Approval of details reserved by condition imposed under ref AL/64/20/PL relating to Condition Nos 5 - pre-commencement site meeting with Tree Officer, 6 - mitigation method statement, 7 - archaeology, 8 - Construction & Environmental Management Plan, 13 - detailed level survey, 14 - materials & finishes, 15 - details of all new screen walls & fences, 16 - landscaping, 18 - energy efficiency measures, 19 - covered & secure cycle parking spaces, 21 - broadband, 22 - charging of electric vehicles and 25 external lighting.

Springfield Hook Lane Aldingbourne PO20 3TE

Condition Number 15

Arun District Council have decided to **REFUSE details reserved by condition for the following reasons:**

IMPERIAL HOMES LIMITED			
CLIENT		HOOK LANE ALDINGBOURNE	
TITLE	TJK1973	SHEET	SHEET 1 OF 1
JOB NO.		DATE	MAY 2021
CHECKED BY	S.K.	DRAWN BY	T.J.K.
LEVEL DATUM	Stn GPS on survey issued		
		SCALE	1:200

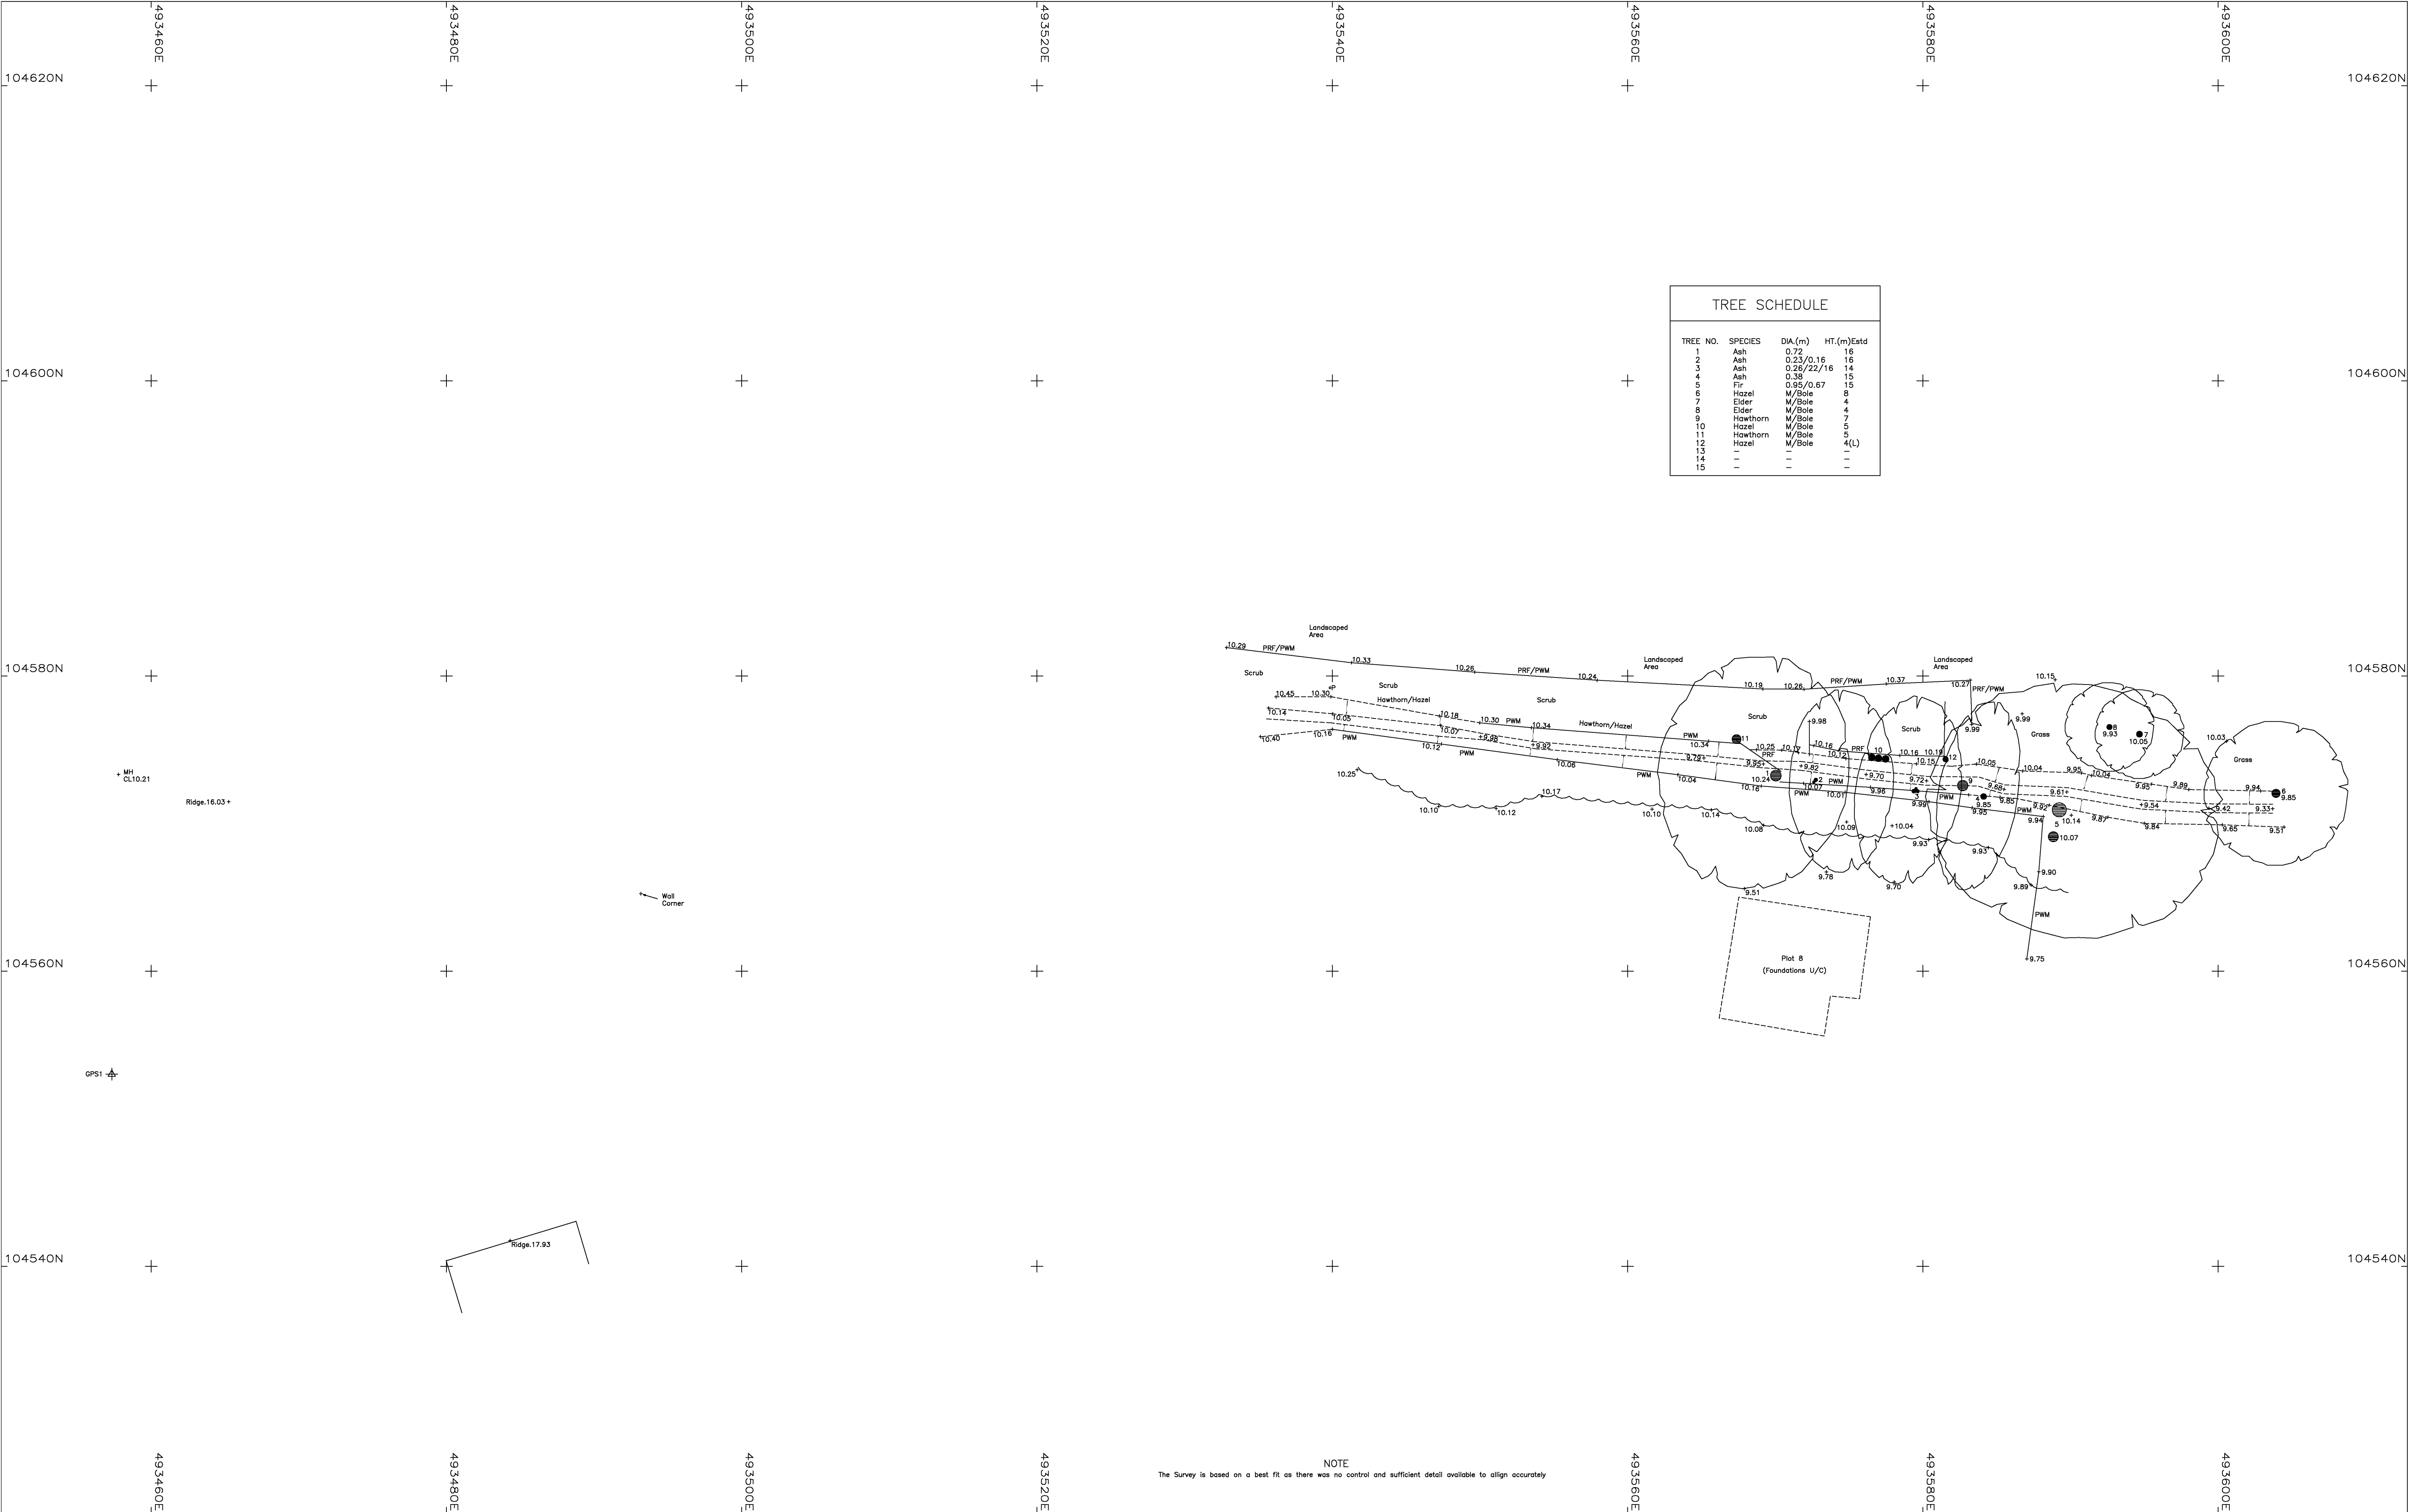
However, it is not possible to agree the condition at this time as the ditch survey is not complete. The survey as provided does not extend sufficiently far enough to allow for verification that the required easement is provided. The survey should also include details of the downstream pipe invert. Therefore, please resubmit the application once the extended ditch survey has been completed.
